Application by Gatwick Airport Limited for an Order Granting Development Consent for the Gatwick Airport Northern Runway Project (Project Reference: TR020005)

Written Representation

West Sussex County Council (IP 20044715)

March 2024

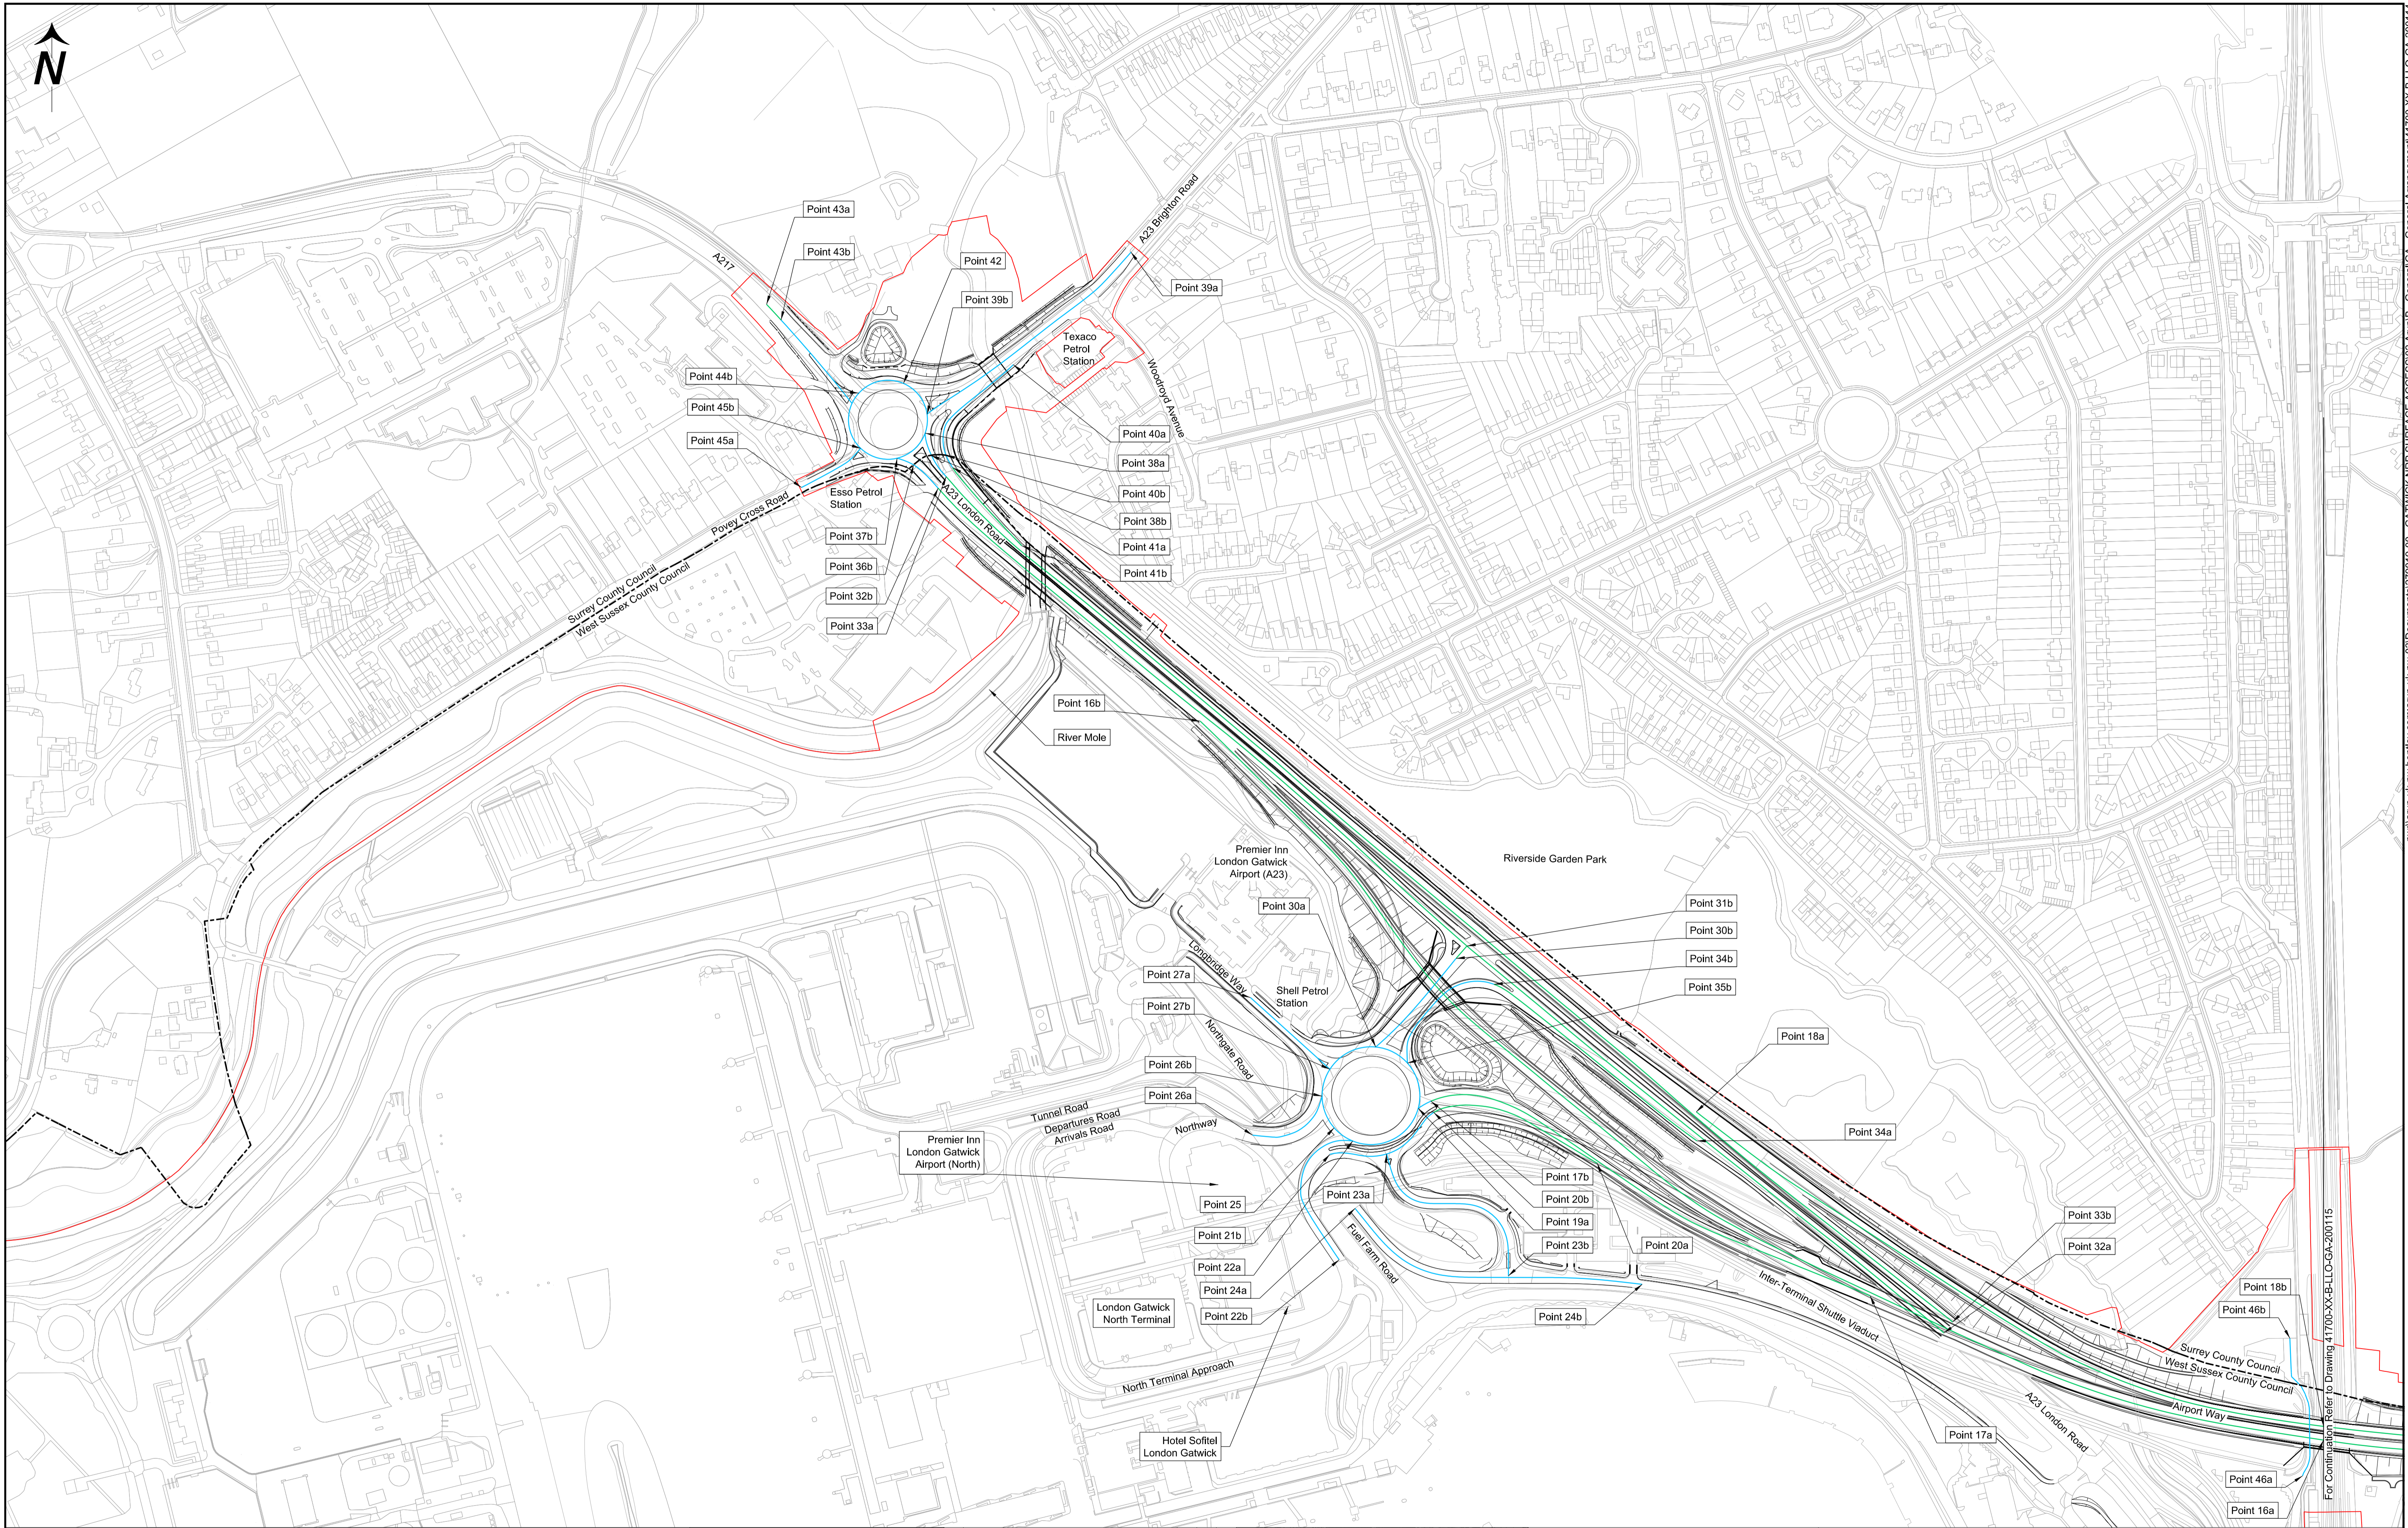
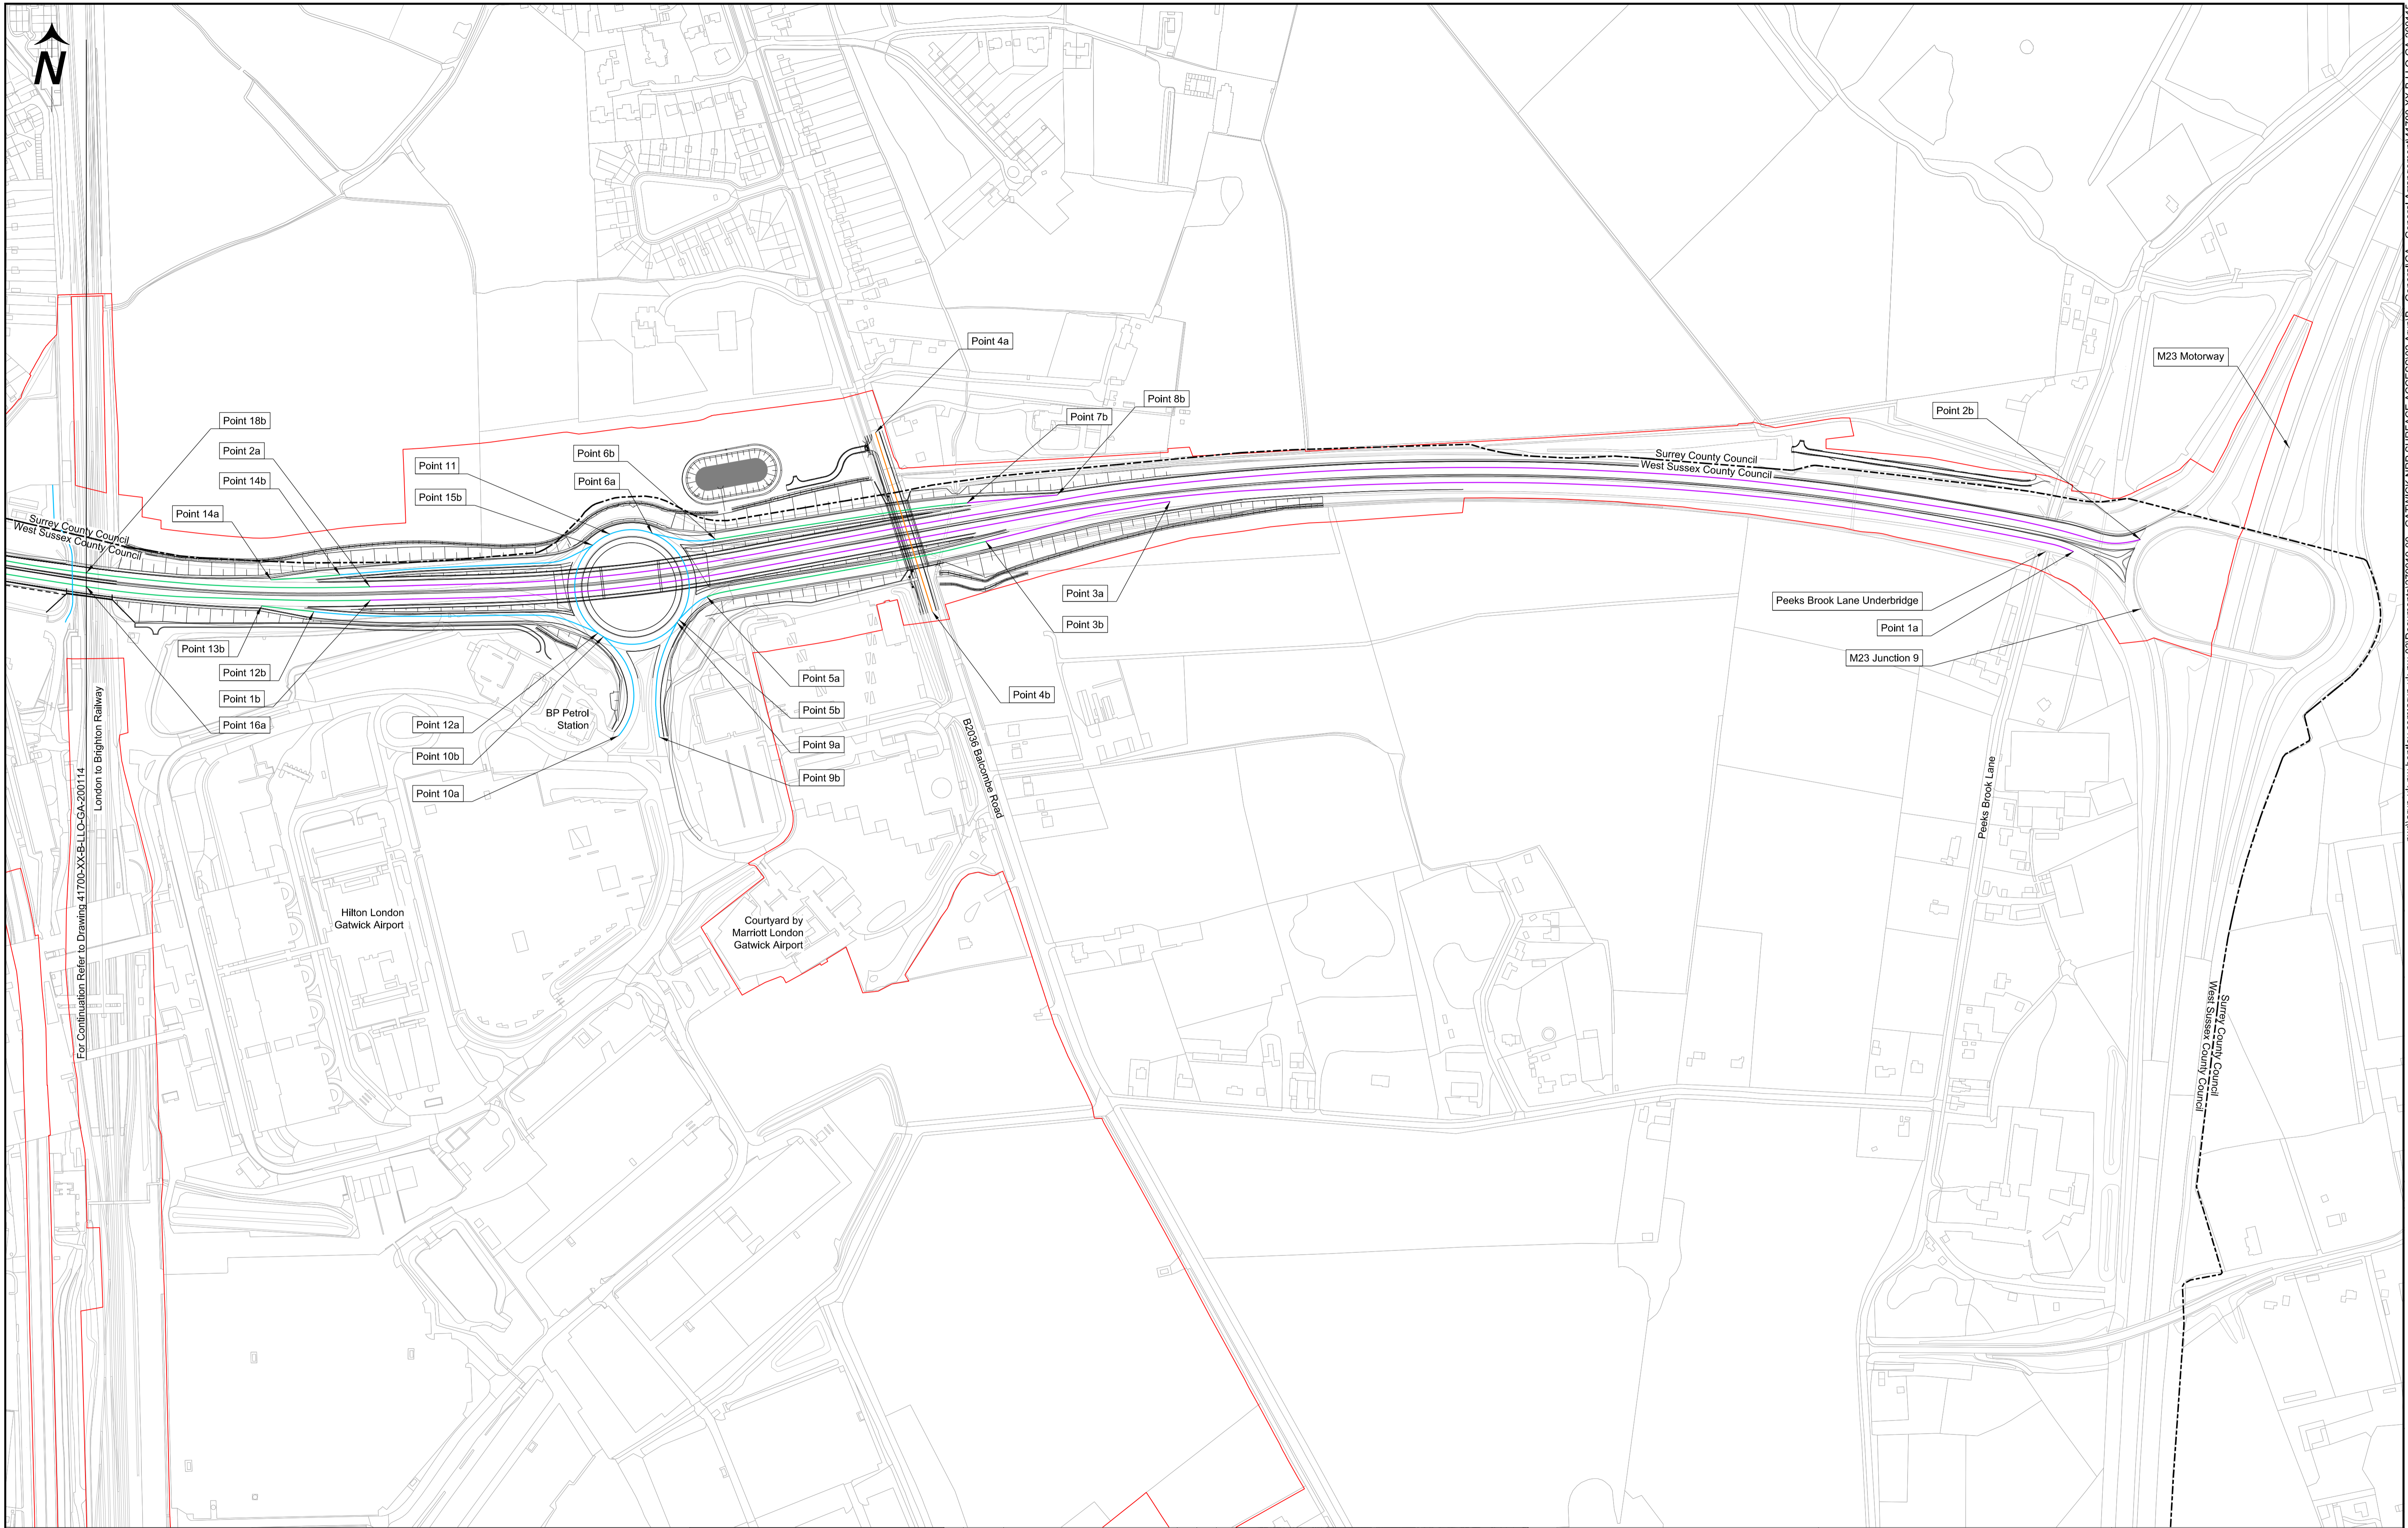
- redistribution of traffic, including from the strategic to the local highway network;
- b. Insufficient justification has been provided for proposed speed limits on the local road network and, in lieu of the submission of a Stage 1 Road Safety Audit, it has not been demonstrated that the road safety implications have been fully considered. It is also not apparent what design standards have been applied to highway works or whether they accord with the relevant standards (as no design review has been submitted); and
